Our ref: DOC21/1039608
Senders ref: SSD-11070211

Subject: EES flood comments on Response to Submissions for New Public School in Mulgoa Rise – 1-23 Forestwood Drive, Glenmore Park – SSD-110702211

TITLE: Existing Flood Velocity - PMF	PROJECT: Mulgoa Rise Public School Flood Study	PROJECT No. 210010	DATE: 04-2021	SCALE: 1:1200	FIGURE No. 07
--------------------------------------	--	--------------------	---------------	---------------	---------------

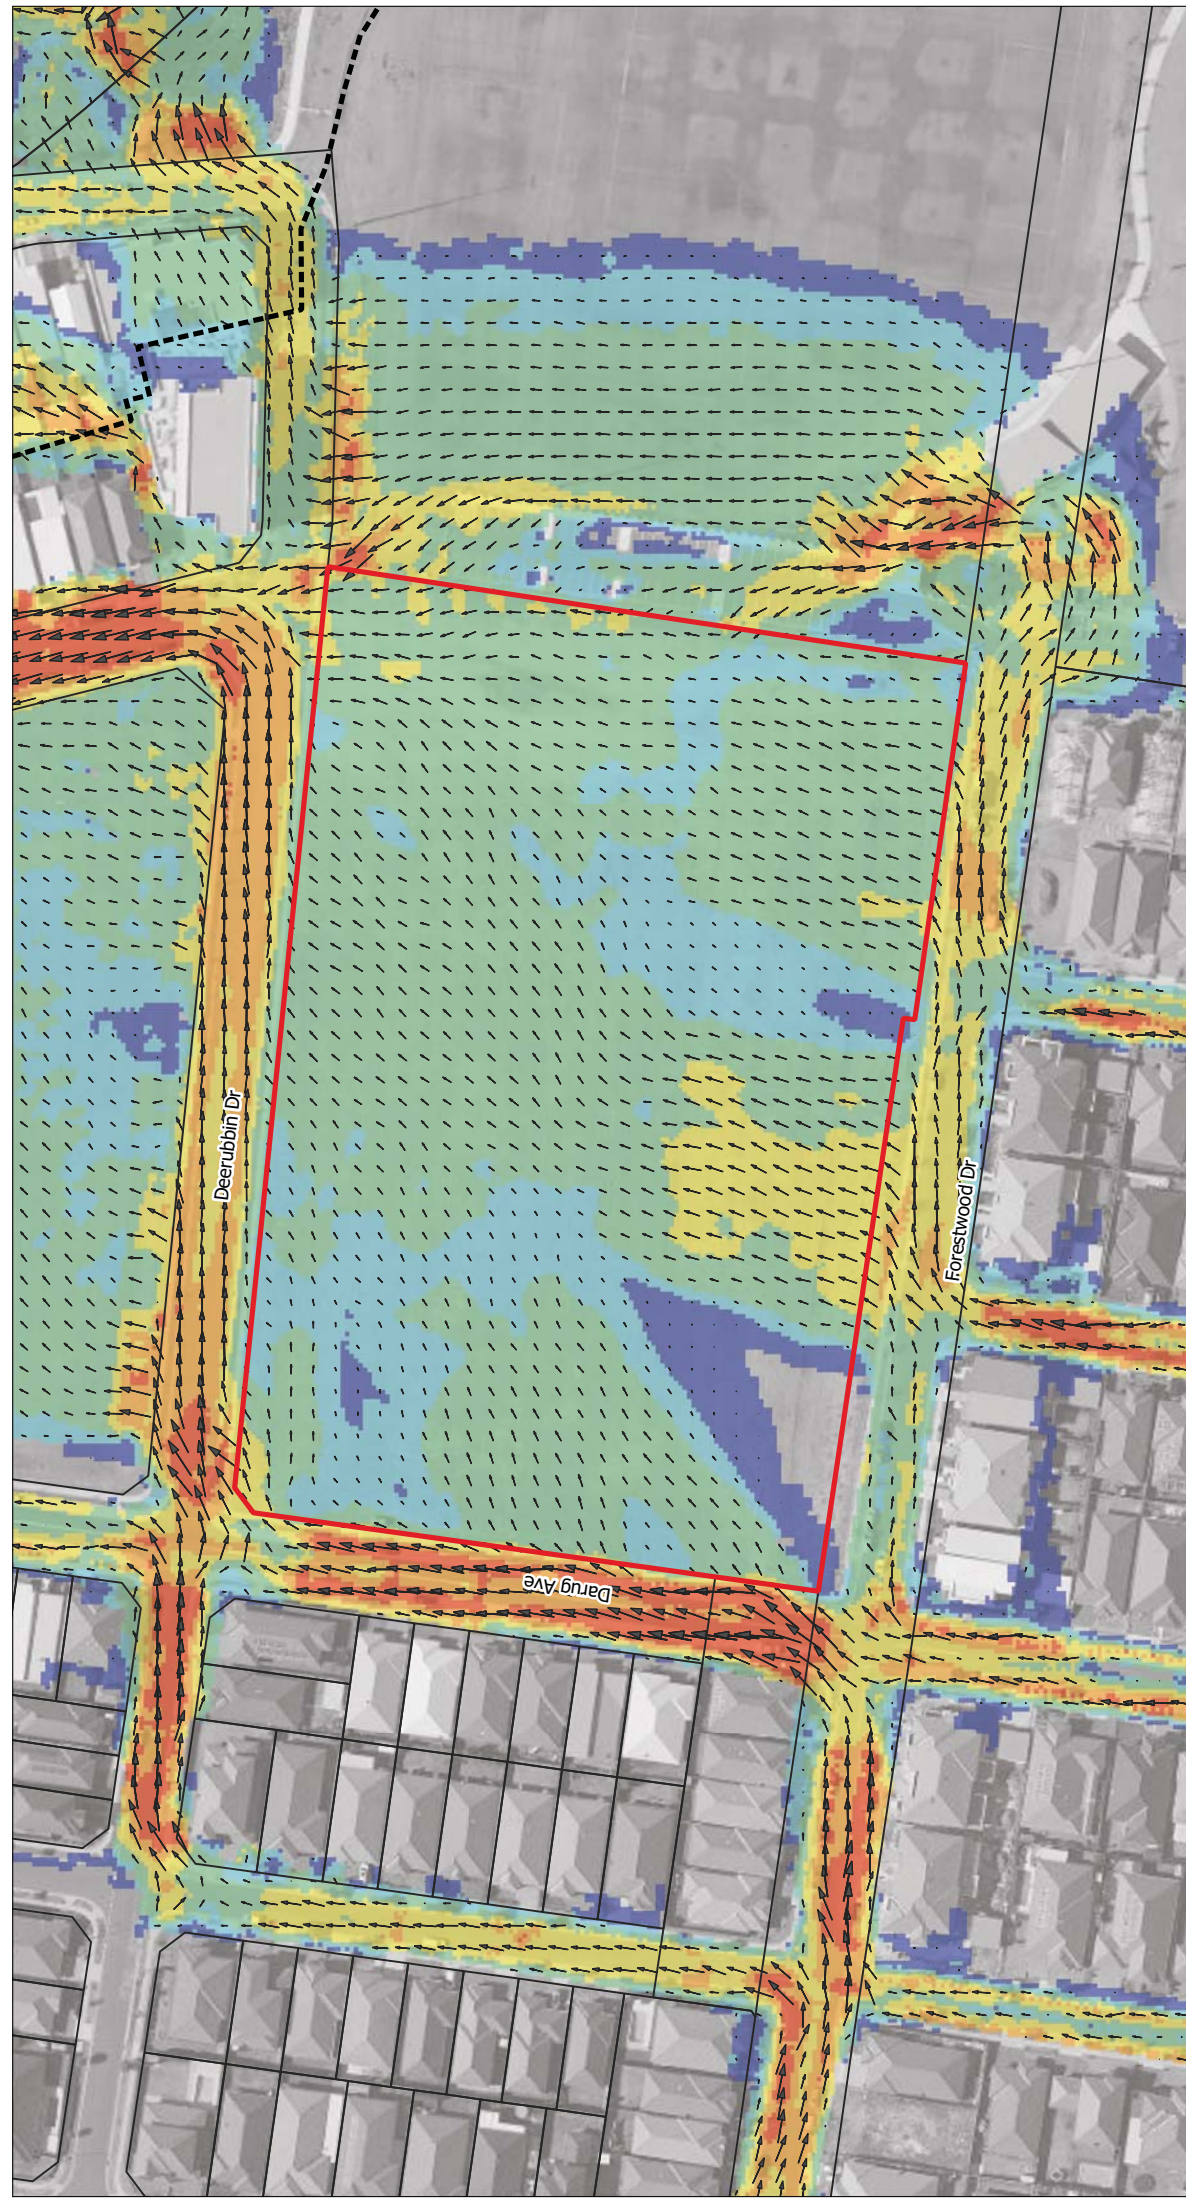
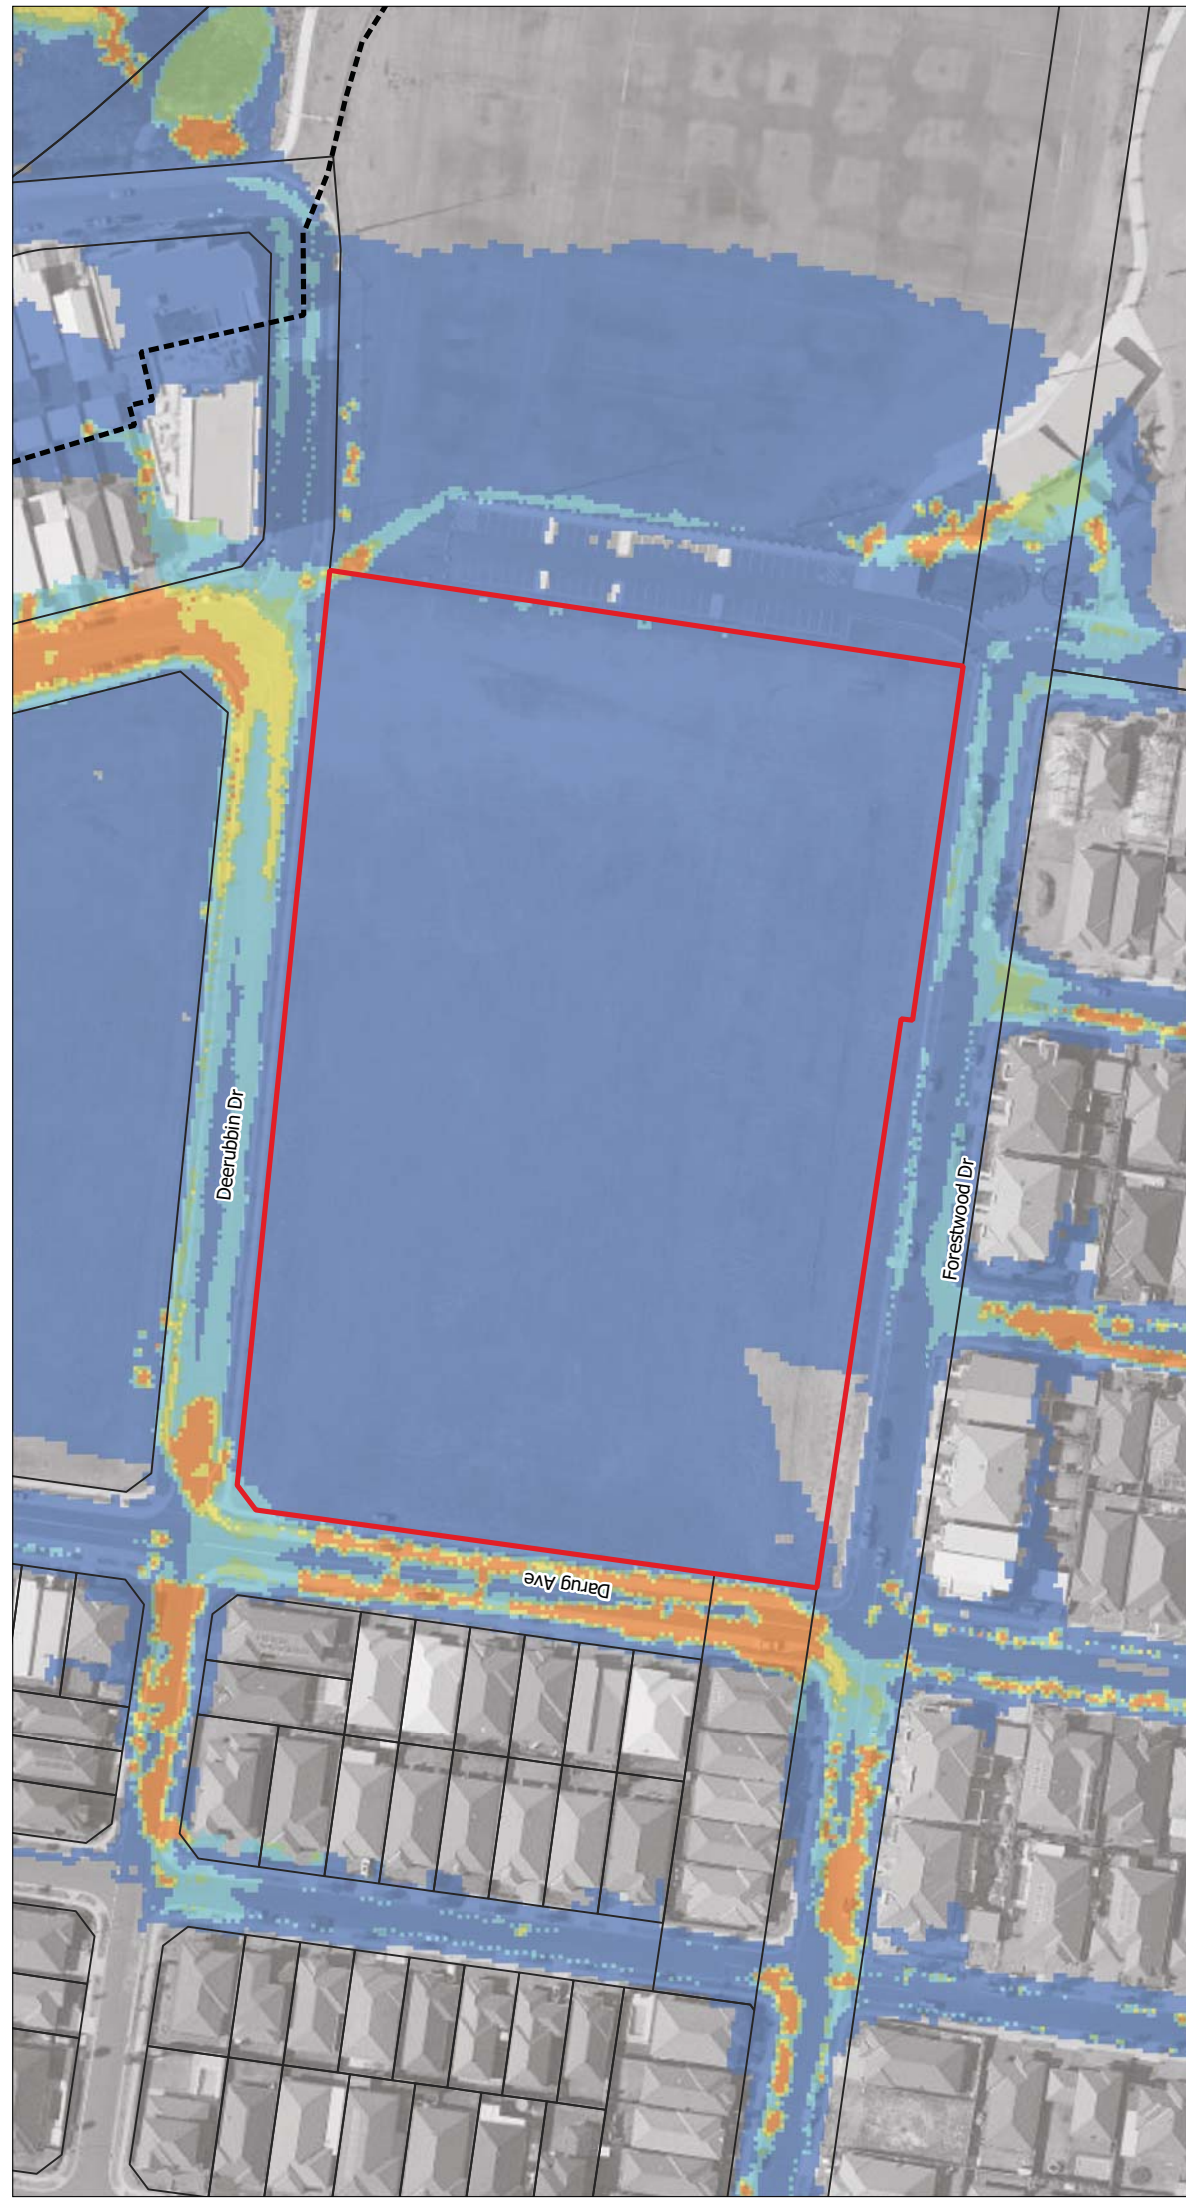
- (1) Review of flood level contours provided in Figure 06 as the contours' levels are inconsistent with the flood depths shown in the maps and the discussion in the report.
 - Figure 06 shows flood level contours at the 90s in the PMF existing condition which is approximately 30m above the site ground level while the flood depth is shown up to 0.3m.
- (2) The access roads to the school are subject to H3, H4 and H5 hazard categories in the PMF event existing condition. The proponent needs to address flood risk in developed condition for the PMF from an emergency management perspective to guide the preparation of the proposed Flood Emergency Plan in relation to the safety measures required in place to ensure the safety of the school community accessing the school in extreme flood events.
